**Washington State
Department of Transportation**

Subject: BL-13-00005 Haberman
I-90, milepost 112.10 Left

We have reviewed the proposed boundary line adjustment and have the following comments.

# PART OF THE SOUTHEAST QUARTER OF SECTION 8, TOWNSHIP 17 NORTH, RANGE 19 EAST, W.M.

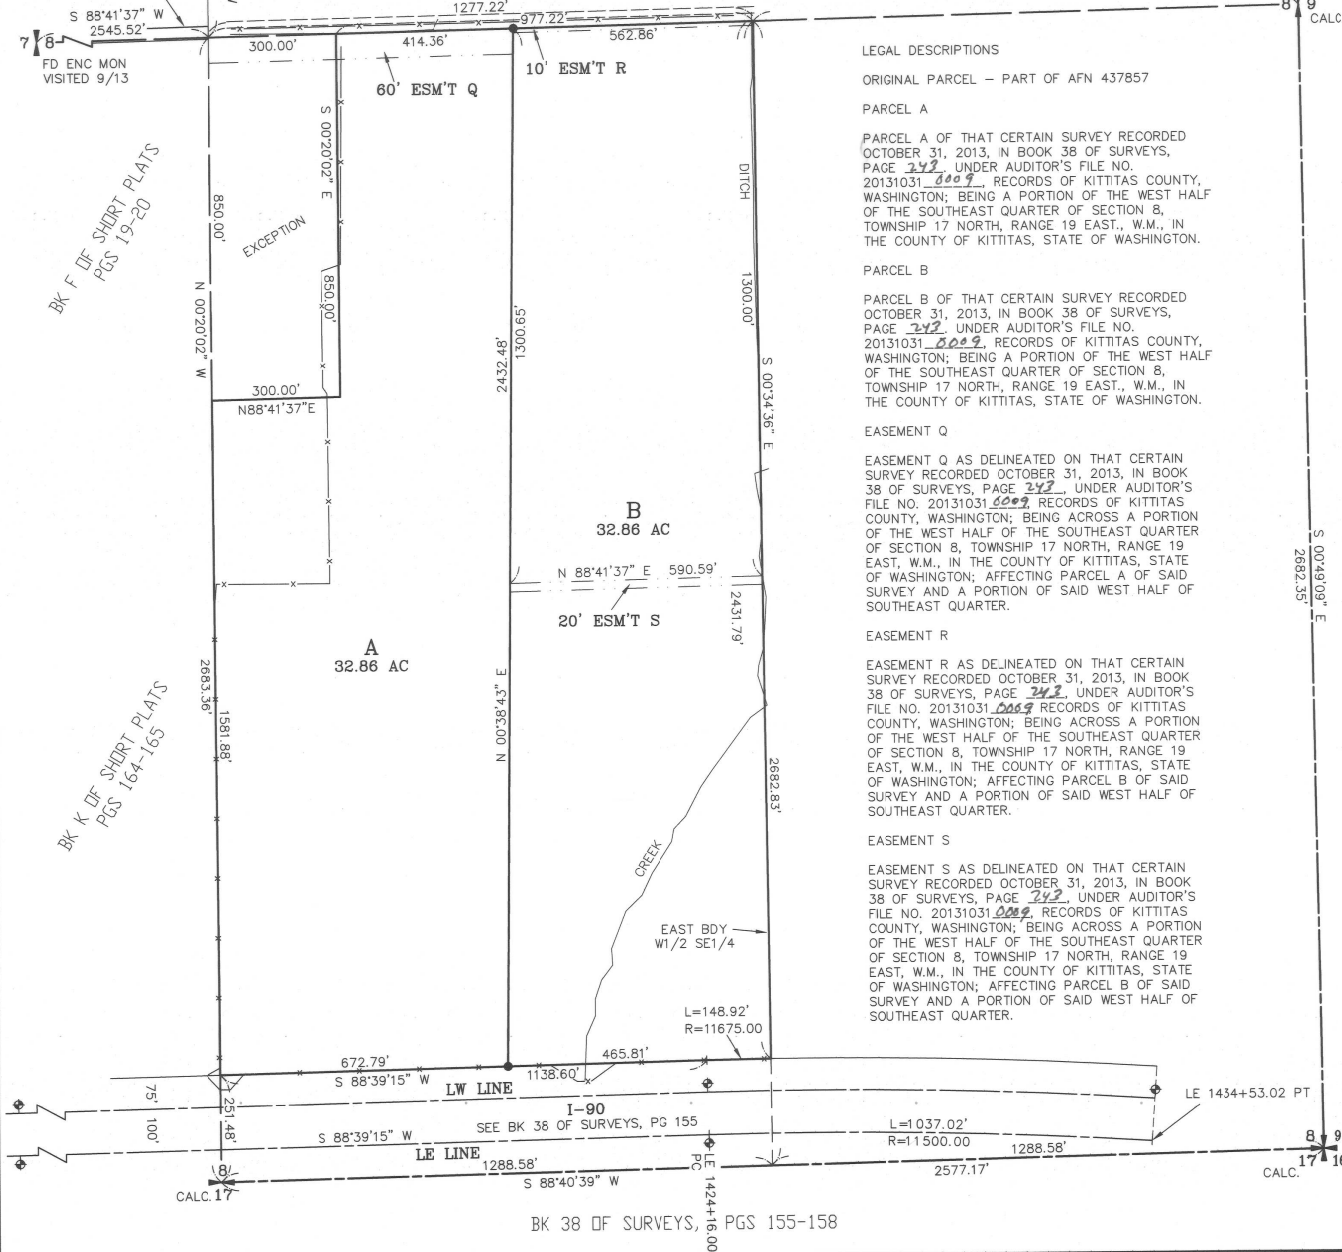
- The proposed project is adjacent to Interstate 90 (I-90), a fully-controlled limited access facility with a posted speed limit of 70 miles per hour. Access to I-90 is not allowed.
- Our records indicate there is a 25-foot drainage easement along the south side of the property, abutting I-90 right-of-way. The property owner(s) are responsible for maintaining this easement.
